# MDT-SF21026-R4-CDs.pdf Markup Summary

RD11

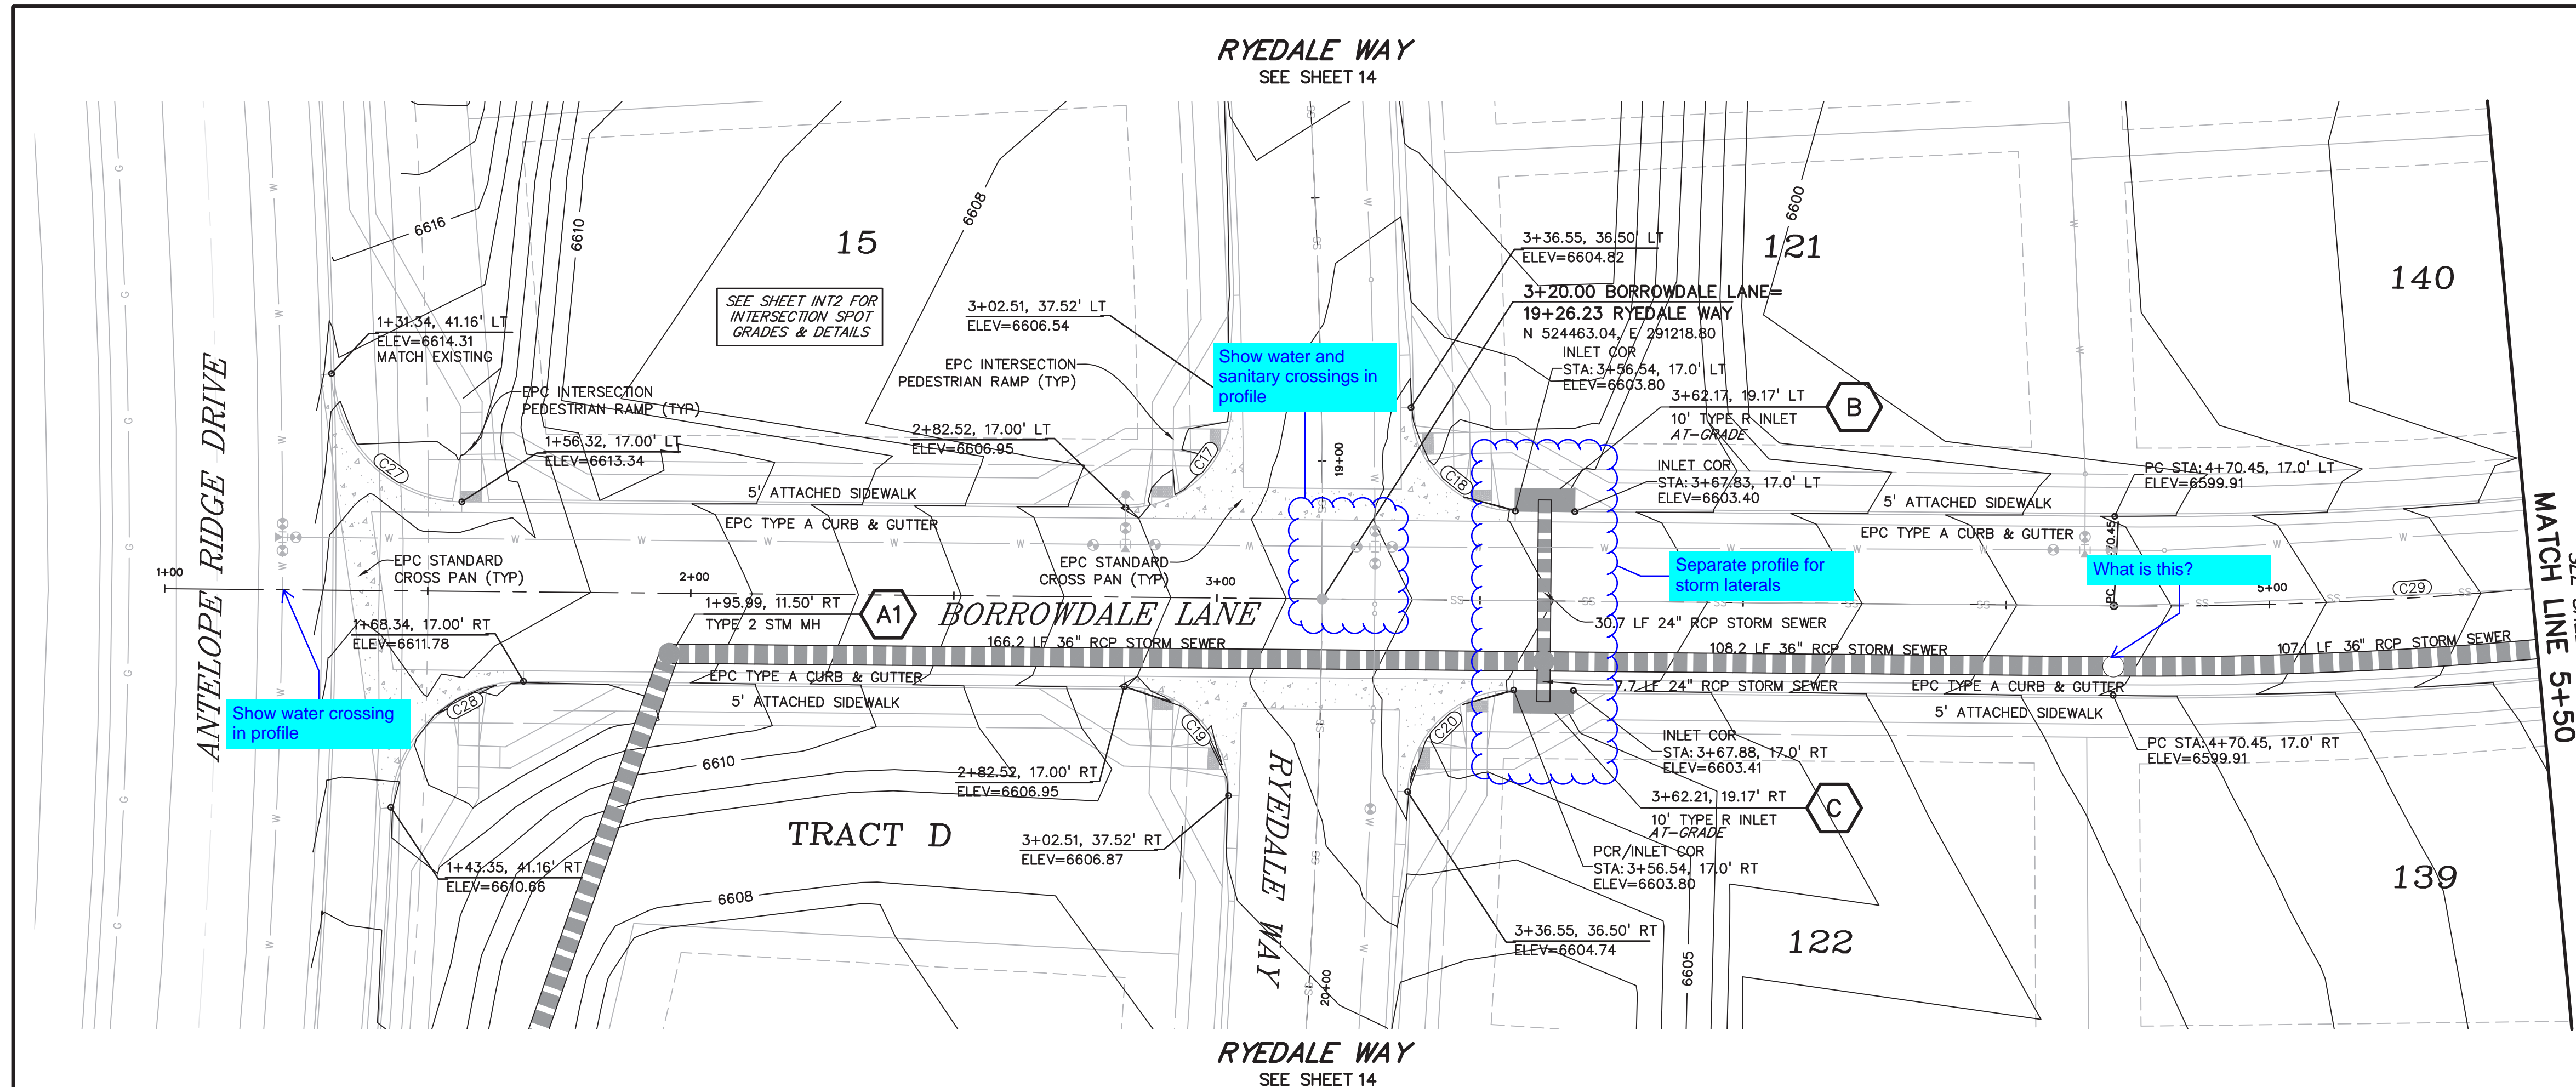
Remove all storm lateral information in profile, All sheets.

Show clearance between water and storm.

This portion of storm sewer (Pipes 9,8B,8A, & 7) per UDSEWER layout are not part of the output information. Please include in next submittal for review.

Label cover over storm

Label cover over storm
